Thankyou for the consultation. The comments of the **Arun District Conservation Area Advisory Panel** are as follows:

Application No: LU/35/22/PL

Site Address: The Nelson Hotel 61 Pier Road Littlehampton BN17 5LP

Description of Works: Alterations to elevations, rear extension and replacement of existing various roofs with new flat roof at second floor to provide refurbished and extended bar, restaurant, function room and guest accommodation. This application is in CIL Zone 4 and is not CIL liable as other development.

Proposed Roof Plan

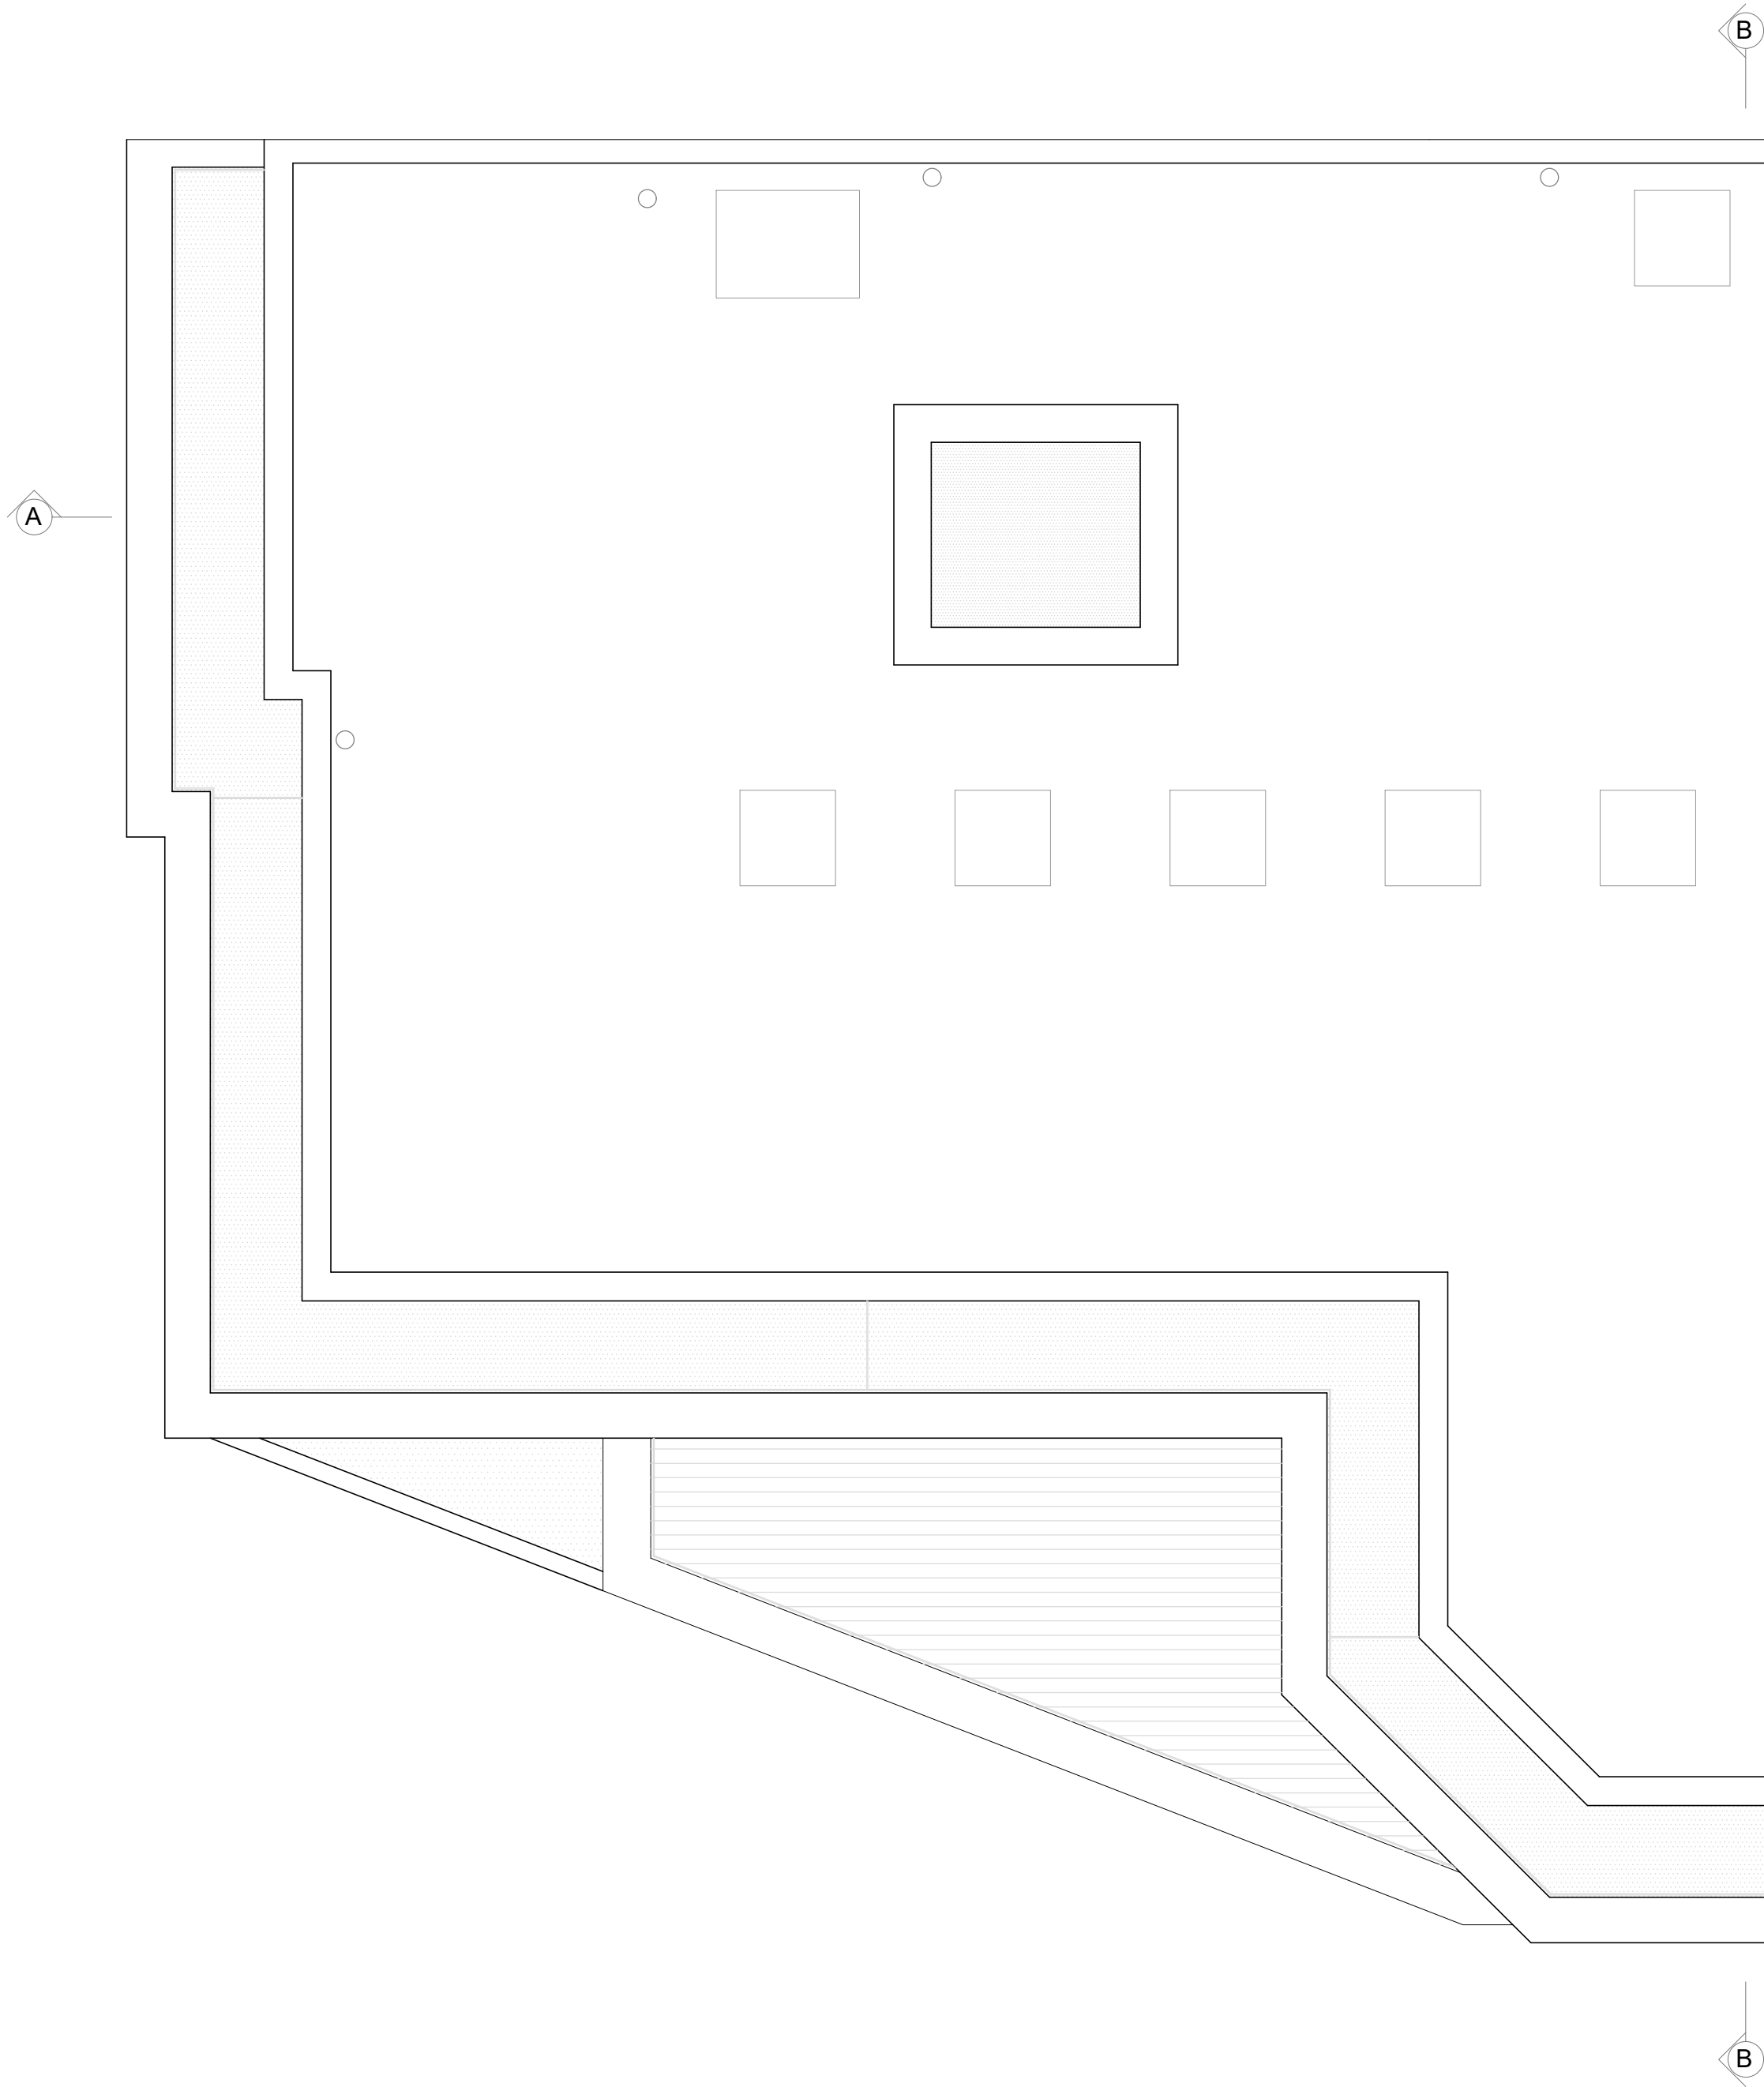
The existing building is to be adapted, with a new roof structure and new fenestration. The latter could perhaps have more appropriate and better proportioned glazing patterns but still retaining a vertical emphasis.

Issued for: Discussion Planning Application X Building Control Construction Issue As Built	
Proposed Elevations	
Client Site Address The Nelson Pier Road Littlehampton West Sussex BN17 5LP	Mr & Mrs Stojanovski
Printed Date Drawing Number	As Shown on A2 18/01/22 15219/02f

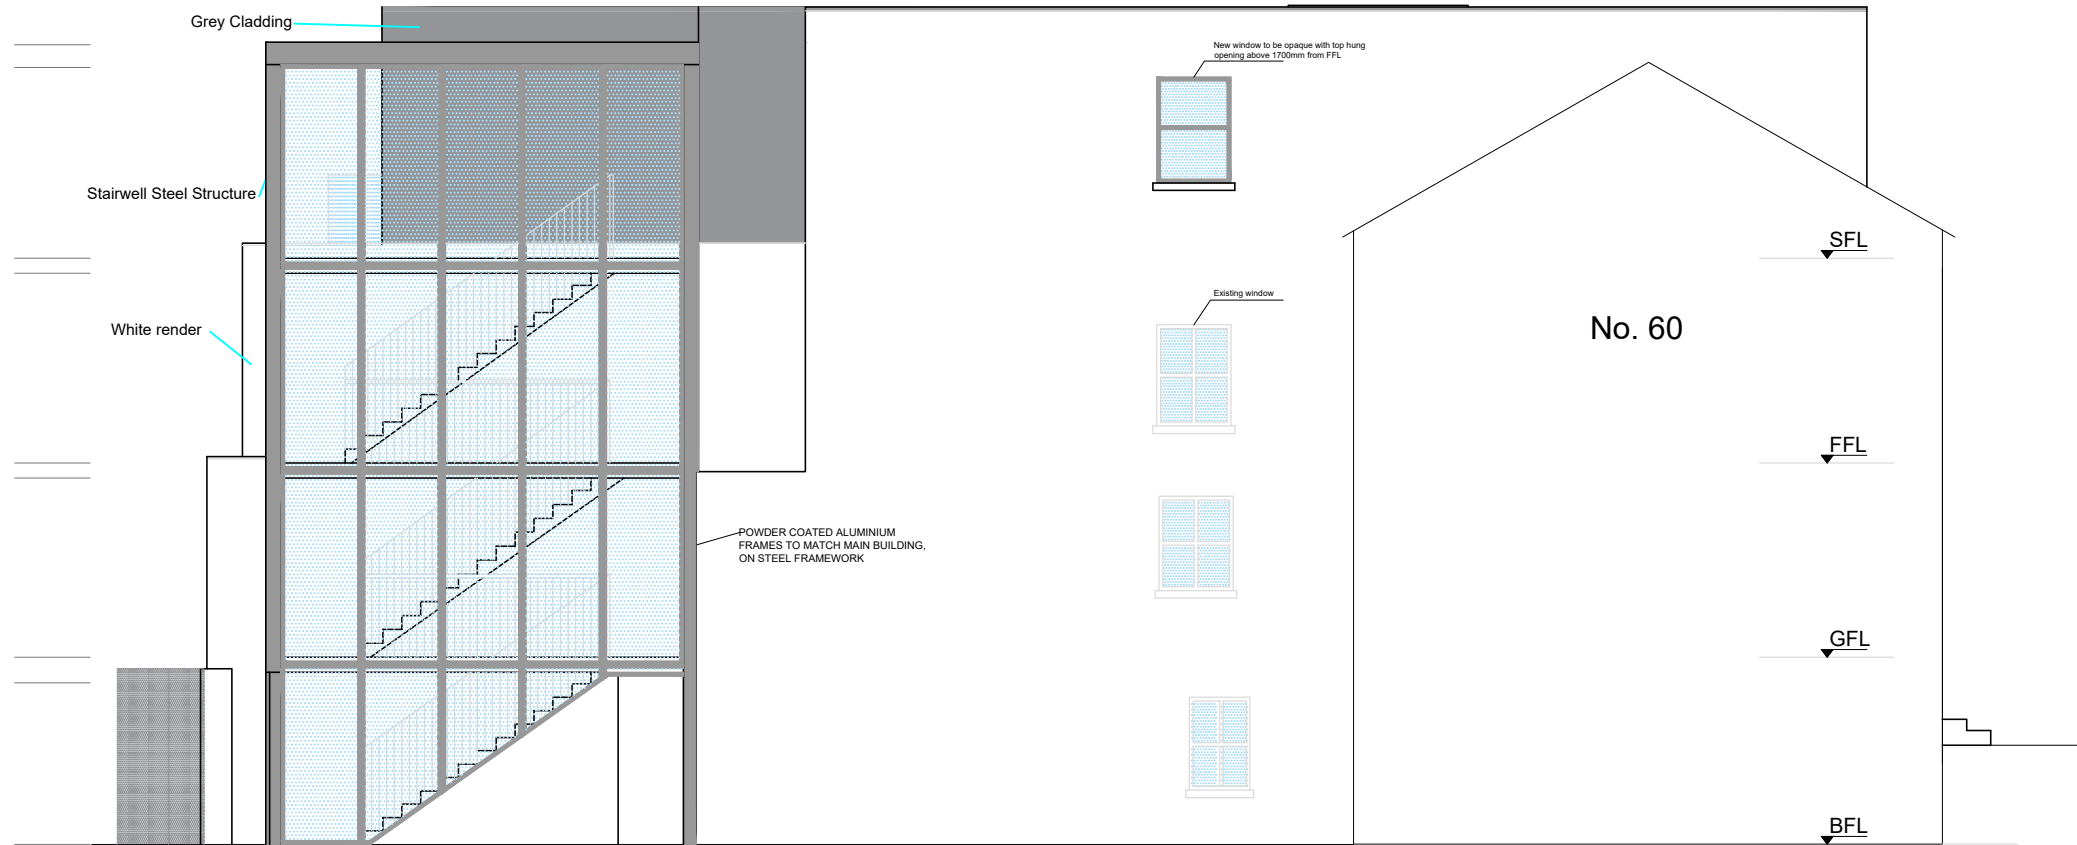
The current application includes a reduction in height from 4 storeys to three from the last application and which is probably a more appropriate height for this location.
